**Addendum No. 1**

RE: Contract ID C202603

**Wayne County (U-3609A)**

US-13 (Berkeley Blvd.) From Royal Avenue To South Drive In Goldsboro

STATE	PROJECT NO.	SHEET NO.
N.C.	U-3605A	Sig. 12
F. A. PROJ. NO.		M 1
PROJECT ID. NO.

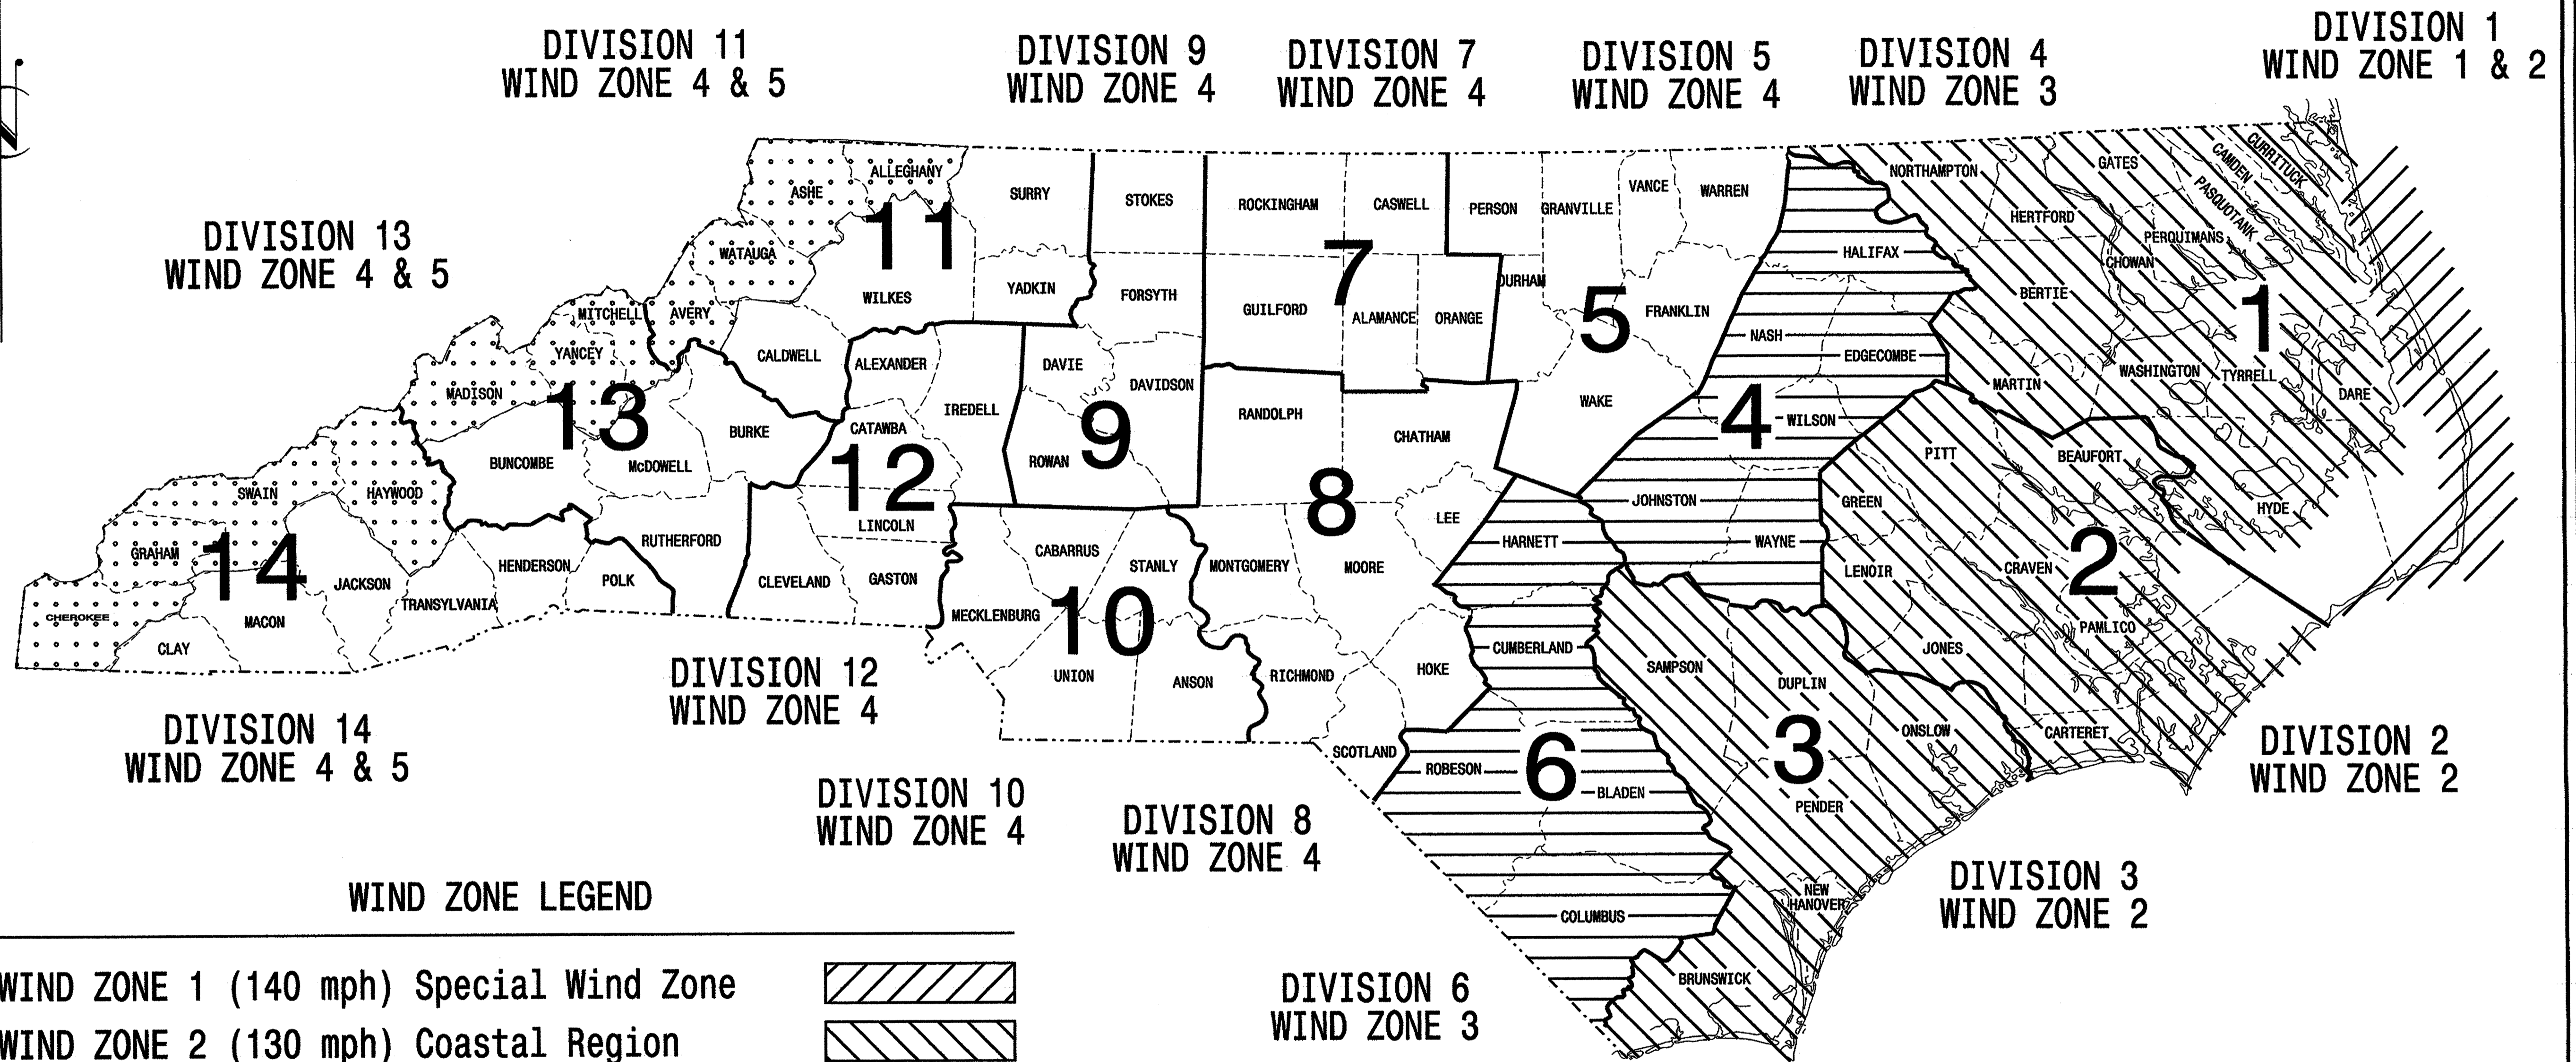
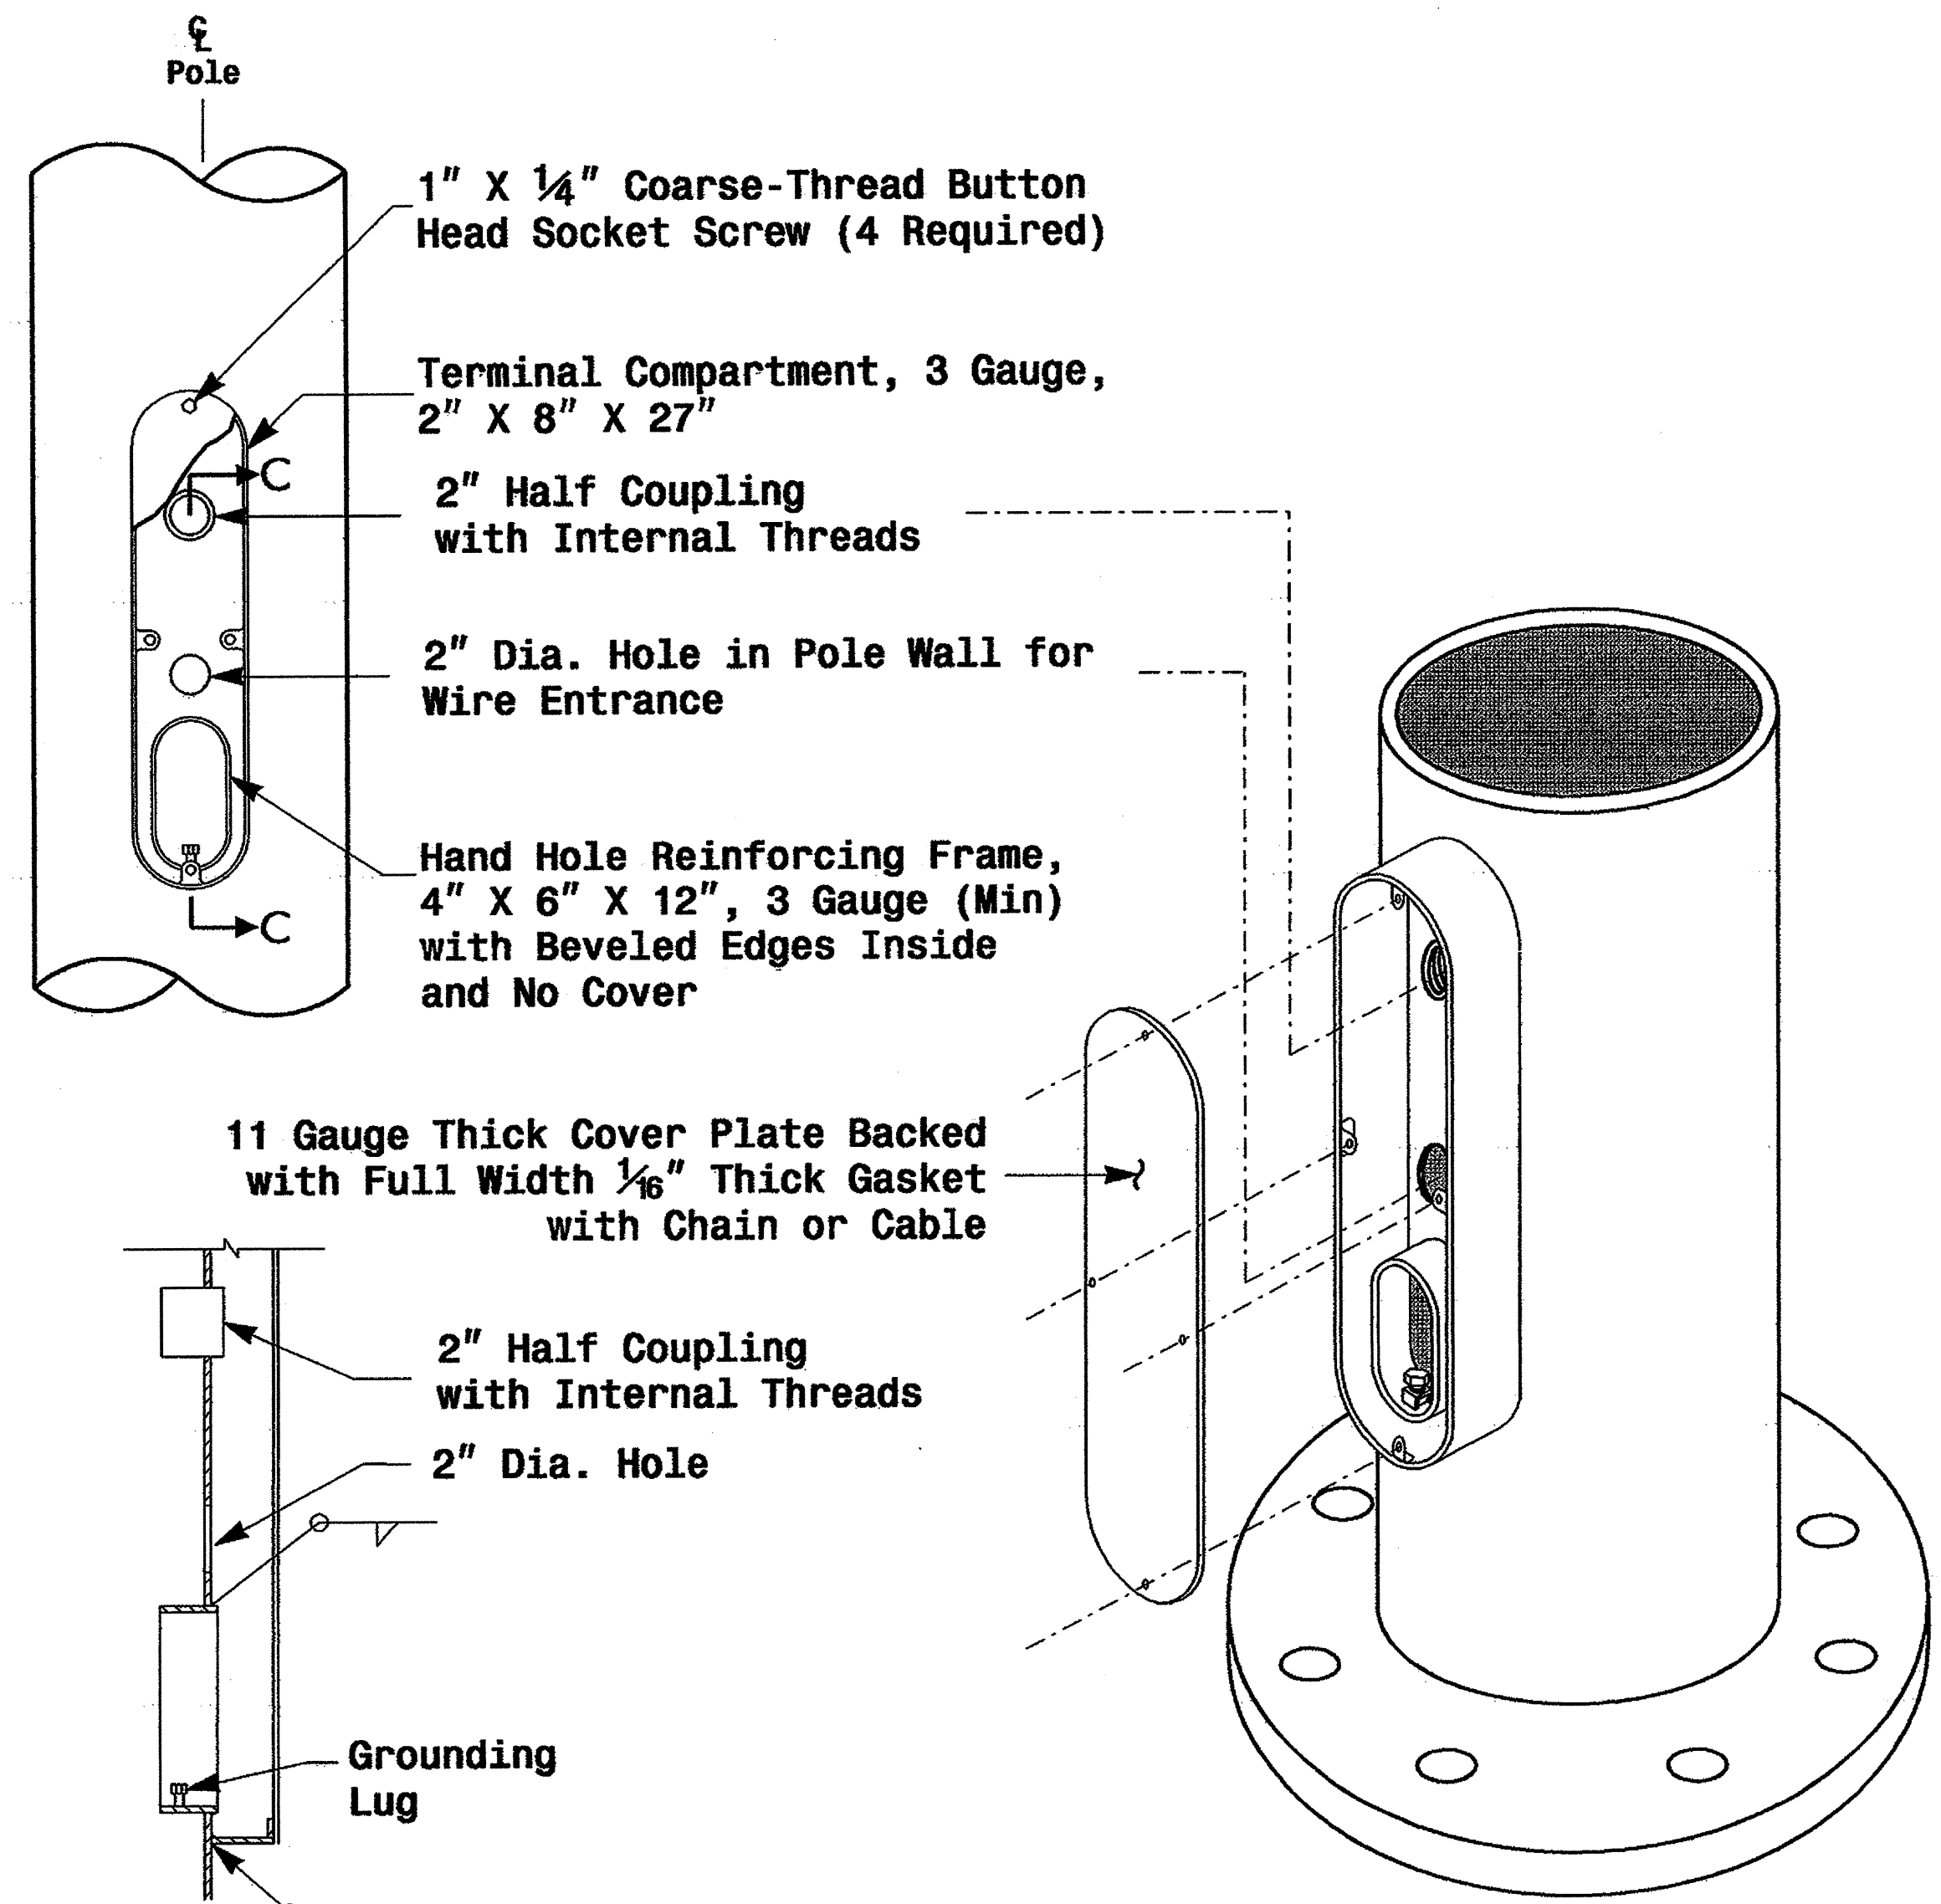
Sheet No. SIG-10 has been revised to show the case number for the metal poles. Please void Sheet No. SIG-10 in your plans and staple the revised Sheet No. SIG-10 thereto.
